Please see LU/261/15/HH

From: Studio5 Architects [REDACTED]
Sent: 23 October 2015 10:15
To: David Easton
Subject: 15.903 10 Mariners Quay_amended drawing 15.903-TP01D

1:50

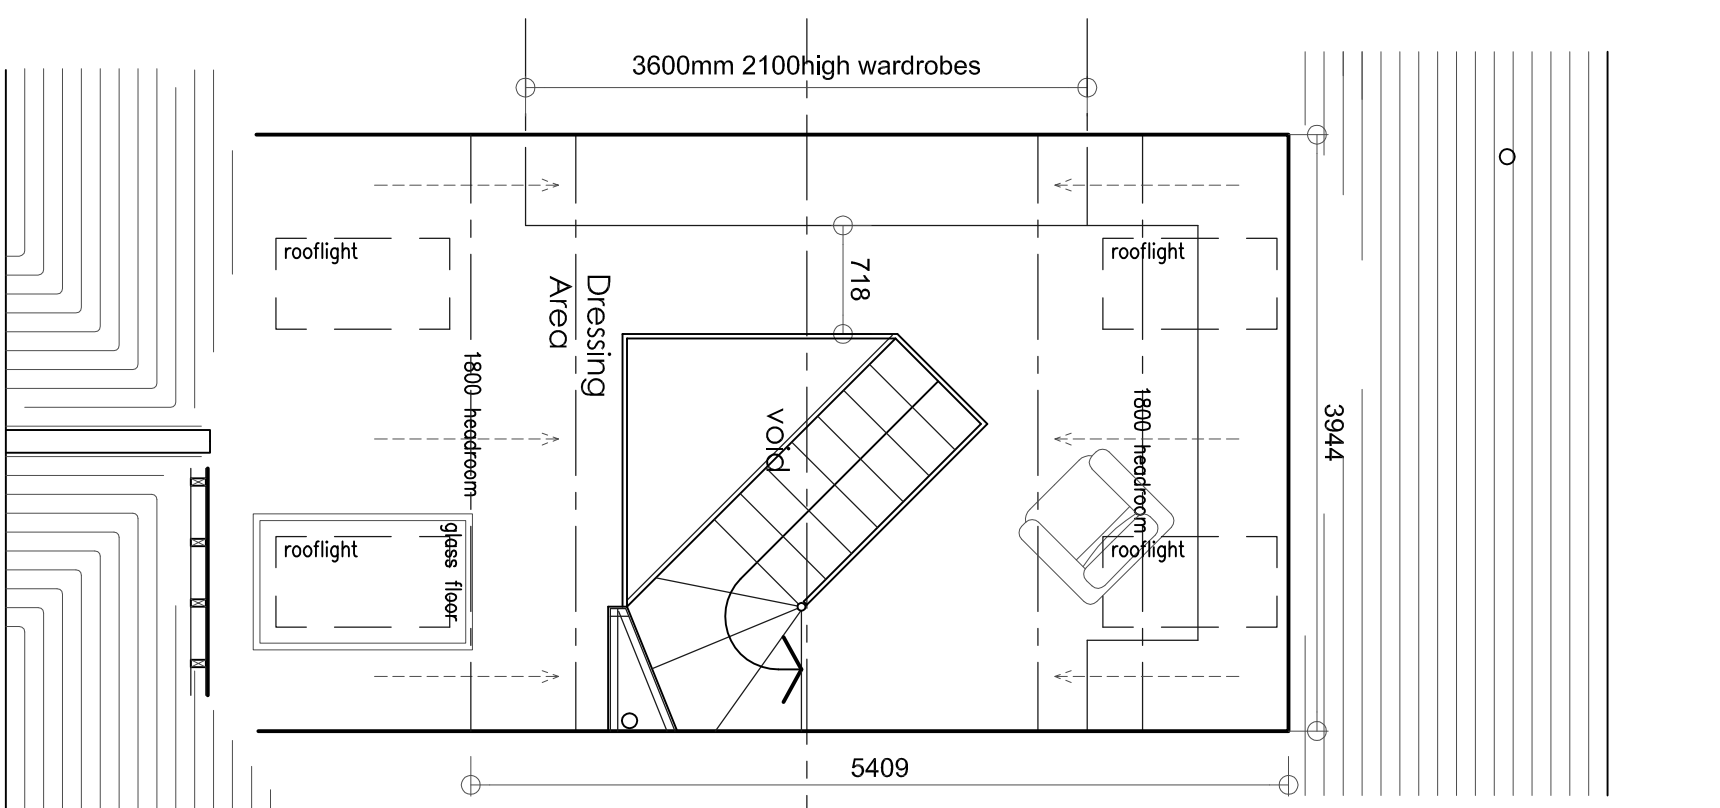
Further to our earlier phone conversation regarding the omission of the Lifting beam, please find attached amended drawing 15.903-TP01D.
